PLANNING AMENDMENT

Application No. H23 / 0641 / 03 / A1

Description: Proposed vehicle showroom, workshop extension and alterations to existing building showroom front elevation

Amendment: Existing workshop internal alterations and new external doors, windows and relocate access door

DRG No. 040/1/2003

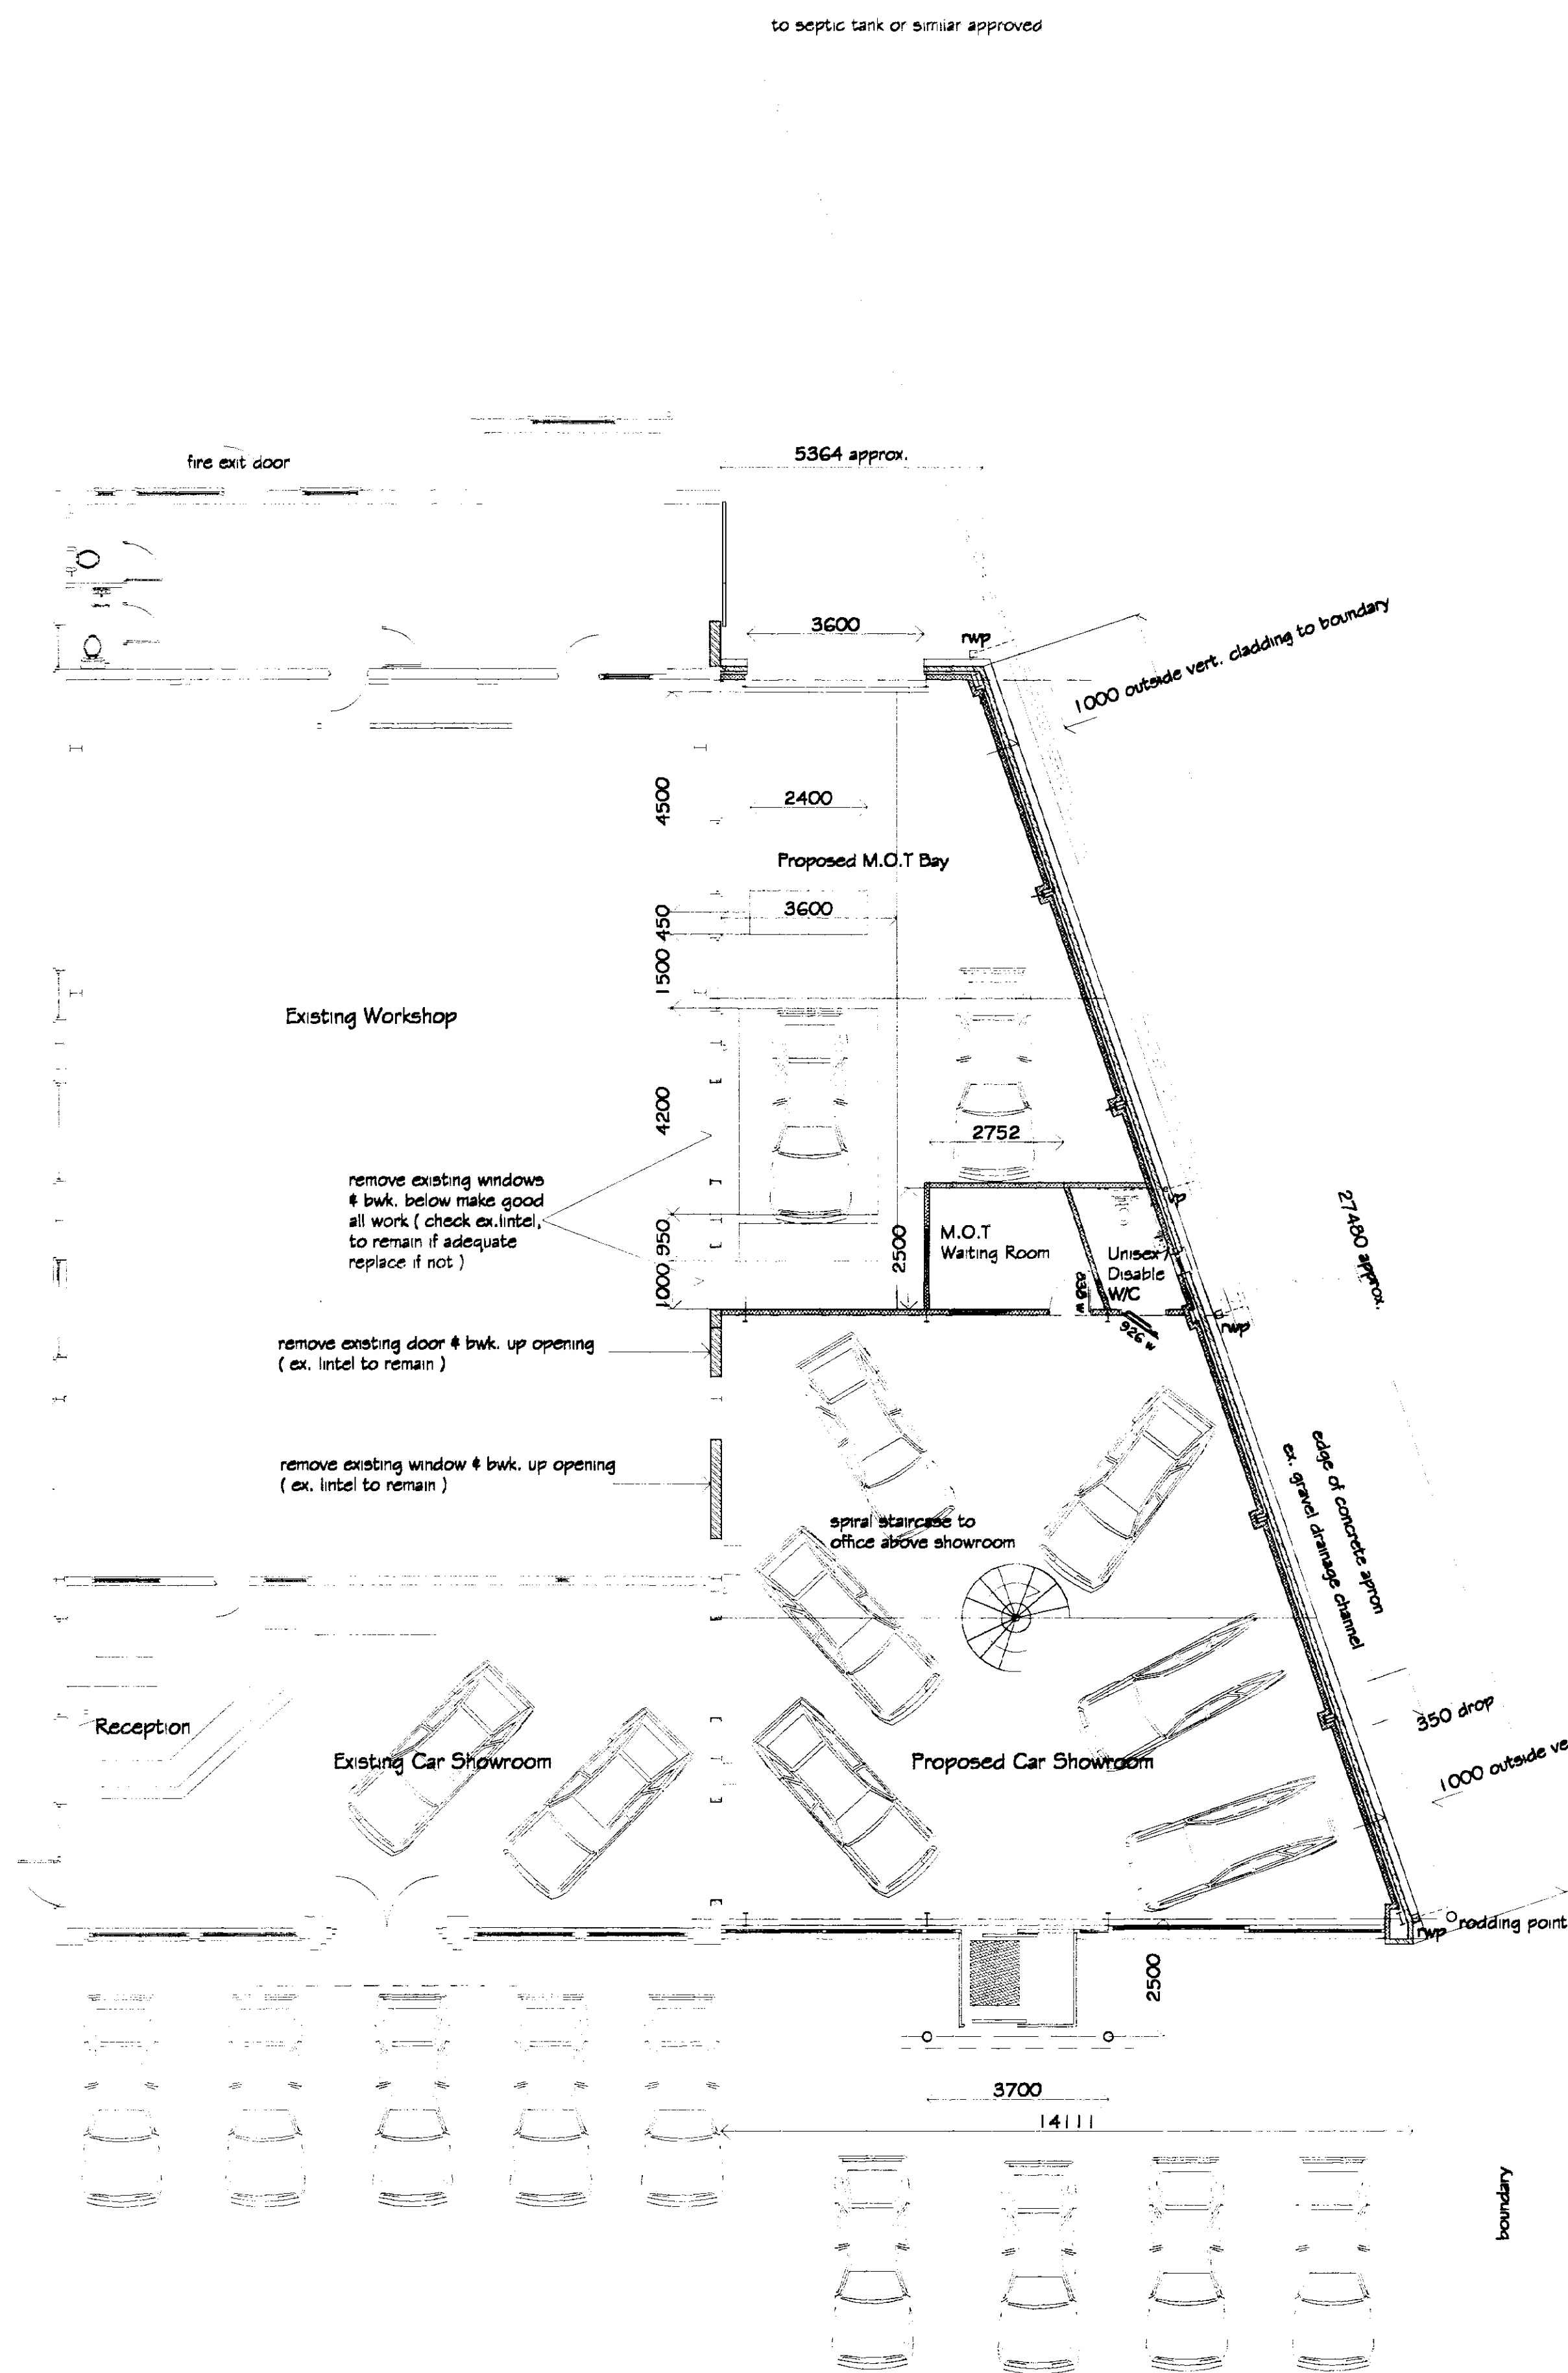
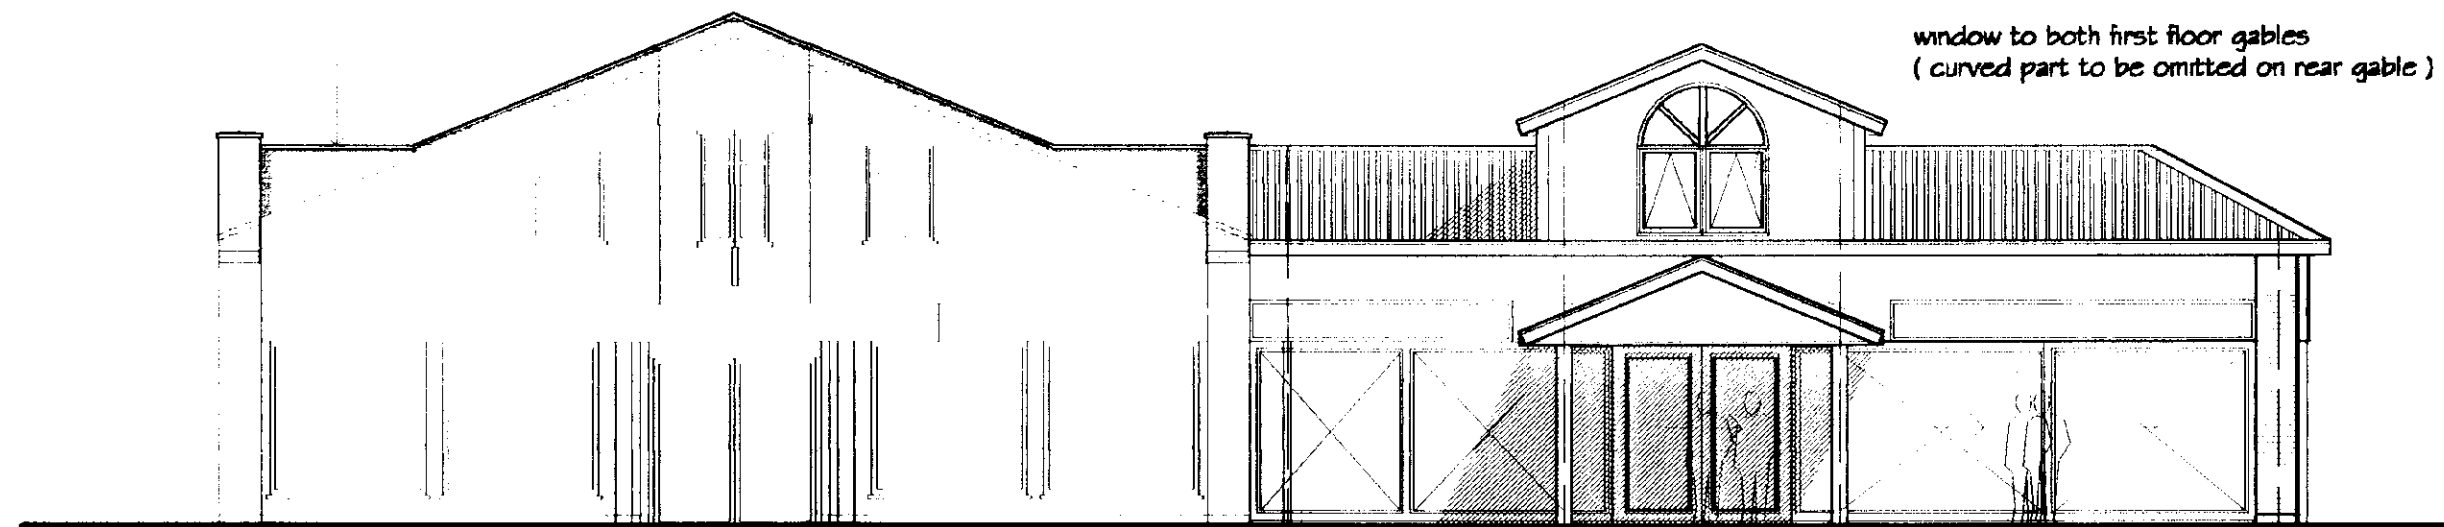
VEHICLE SHOWROOM WORKSHOP
EXTENSION & ALTERATIONS TO
EXISTING SHOWROOM ELEVATION
NEW PARTS DELIVERY / PARTS STORAGE
NOT WAITING ROOM / FIRST FLOOR PARTS
STORAGE ABOVE ALL WITHIN EX. WORKSHOP.
NEW EXTERNAL PERSONNEL DOOR /
WINDOWS + RELOCATE LARGE WORKSHOP
ACCESS DOOR
